Residential development comprising 1x3-bedroom bungalow , 2x3-bedroom houses, 2x2-bedroom houses 4x4-bedroom houses along with access and parking following demolition of existing dwelling - Departure from the Development Plan.

Langford Horsmere Green Lane Climping

Thank you for your internet representation made on 13th January 2020 which has been recorded as '**an objection**' with the comments as follows:

Drg No: 190725/SL-01
Rev: K

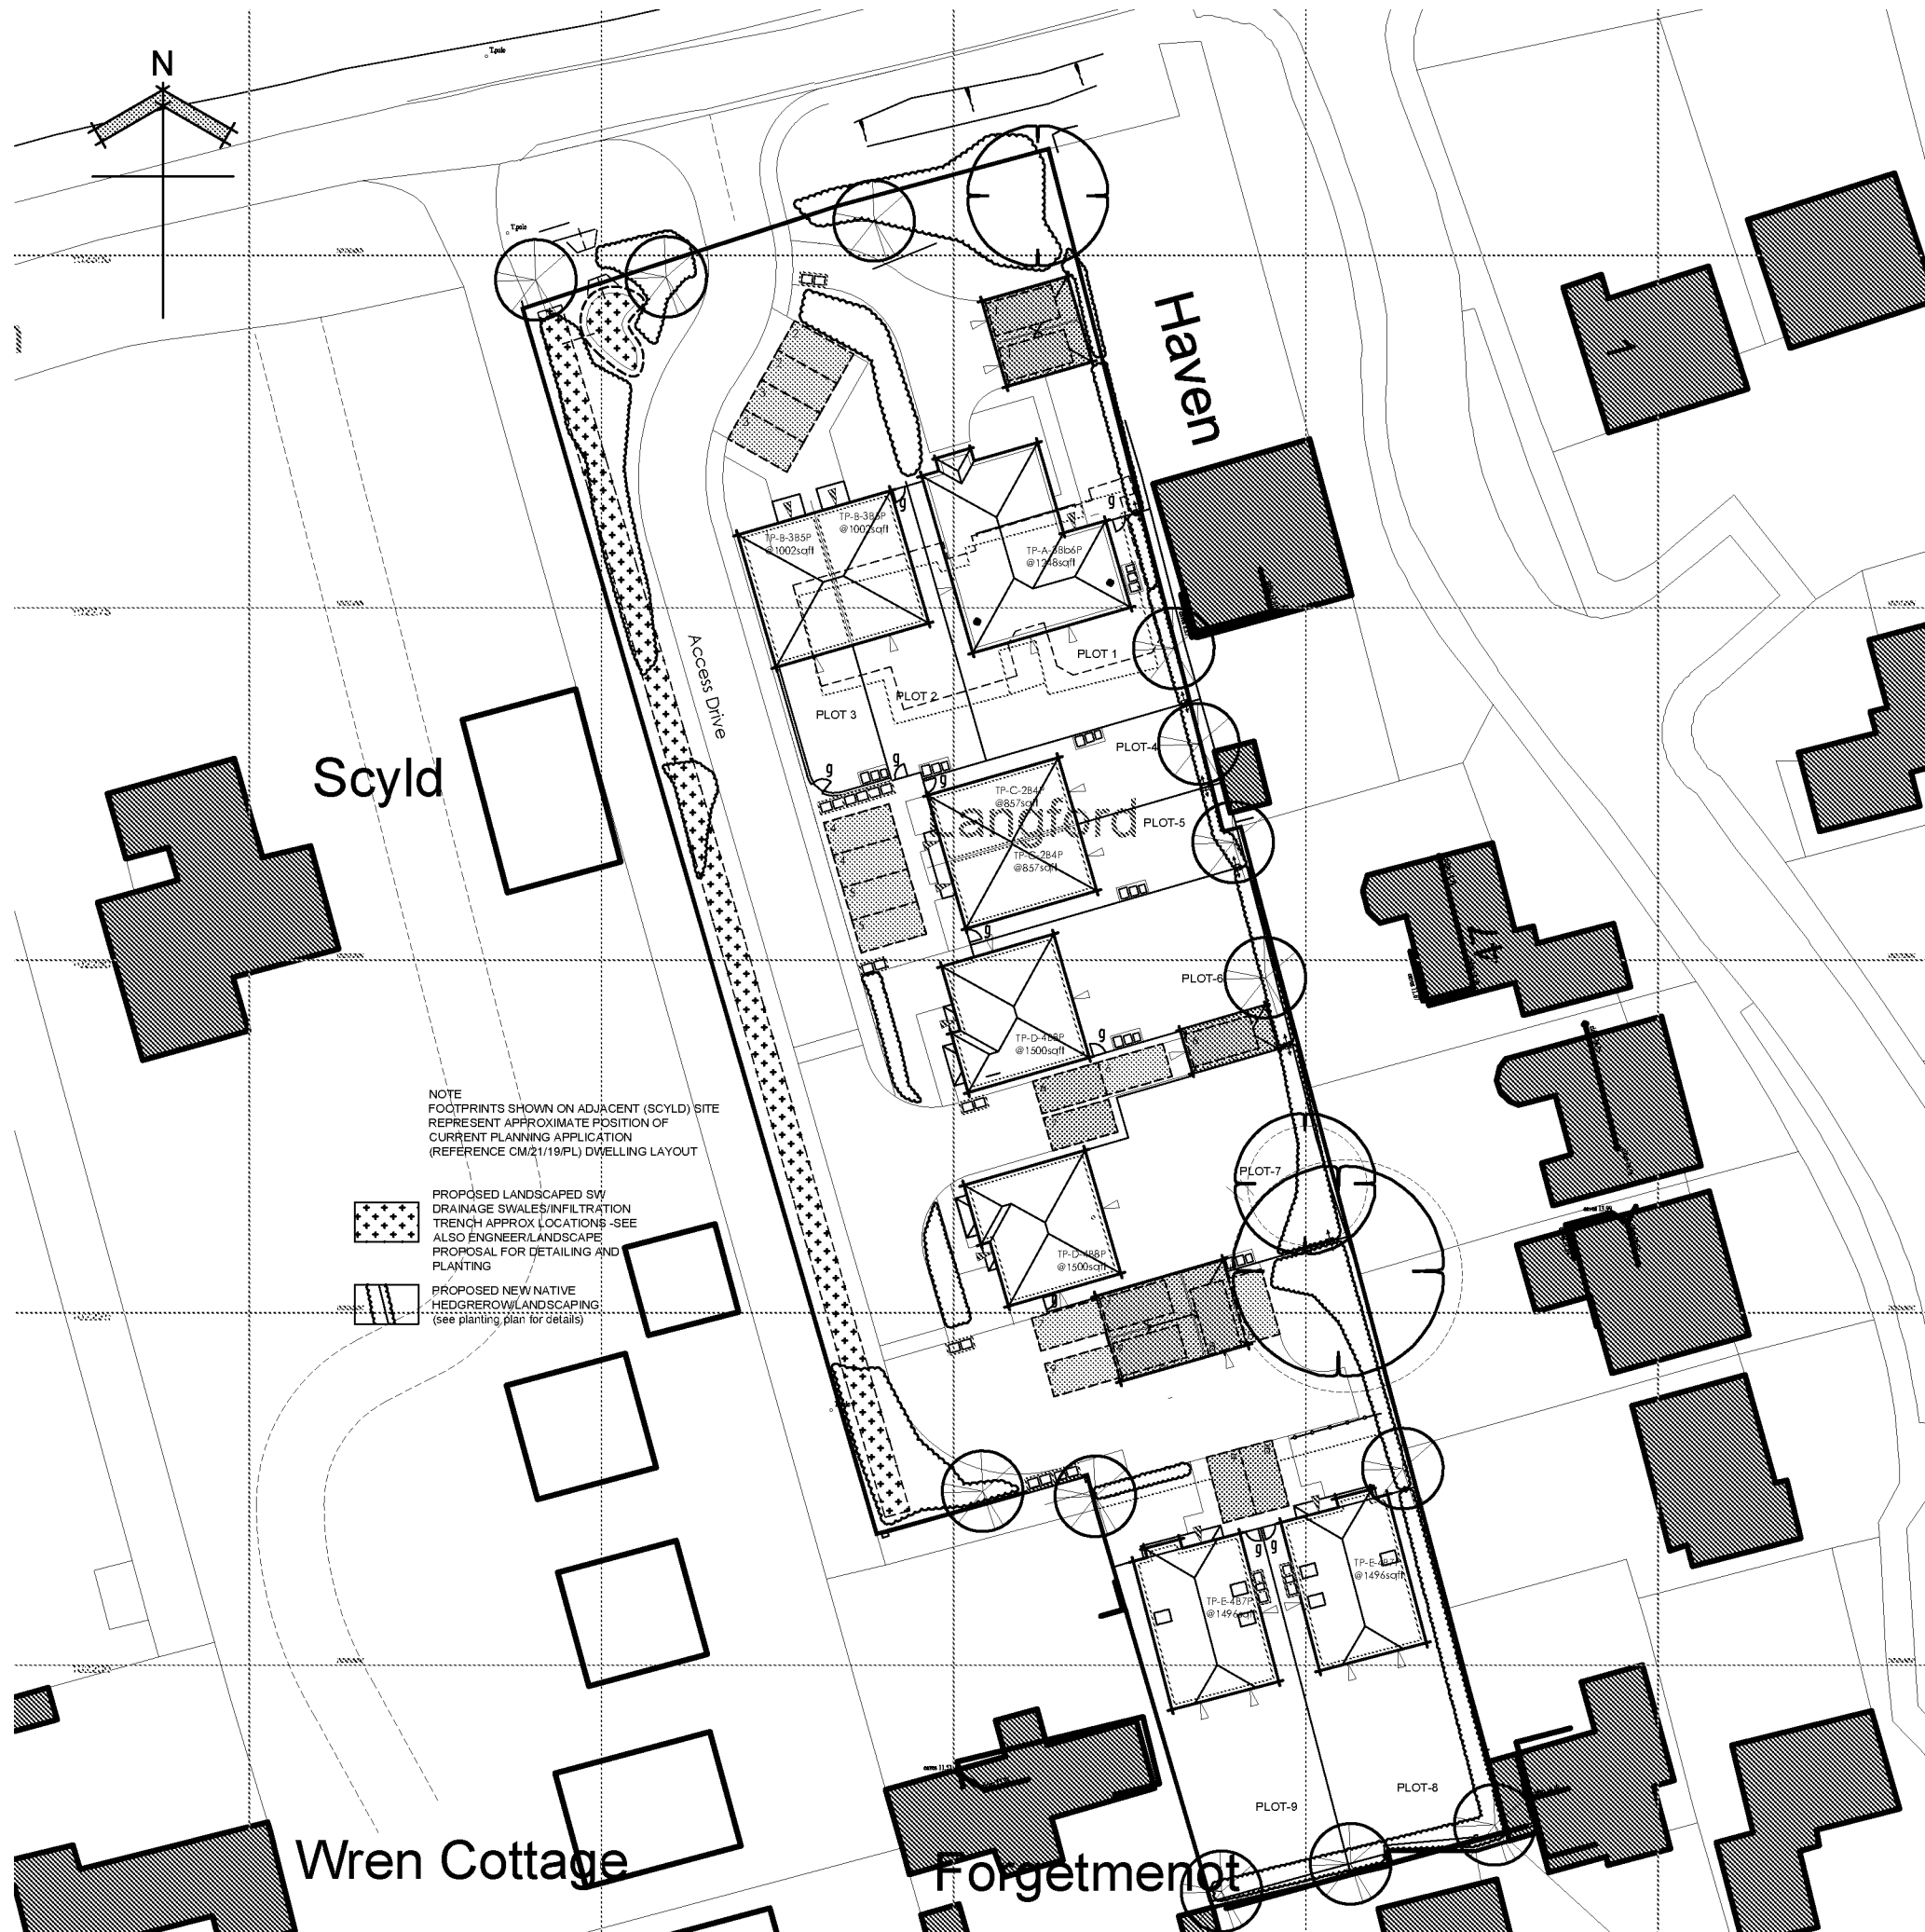
I estimate plot 8 will have a bedroom window almost directly facing my son's bedroom window only 11 metres away and a second bedroom window only 13.5m apart, both these windows are far too close to preserve privacy. Additionally it will have what appears to be a roof window only 16.5m away to a third bedroom.

Plot 9 also has a bedroom window only 18.5m away albeit at a greater angle.

Mindful that many Councils have planning policies that recommend 21 metres or more this house design is clearly unacceptable for plots 8 and 9.
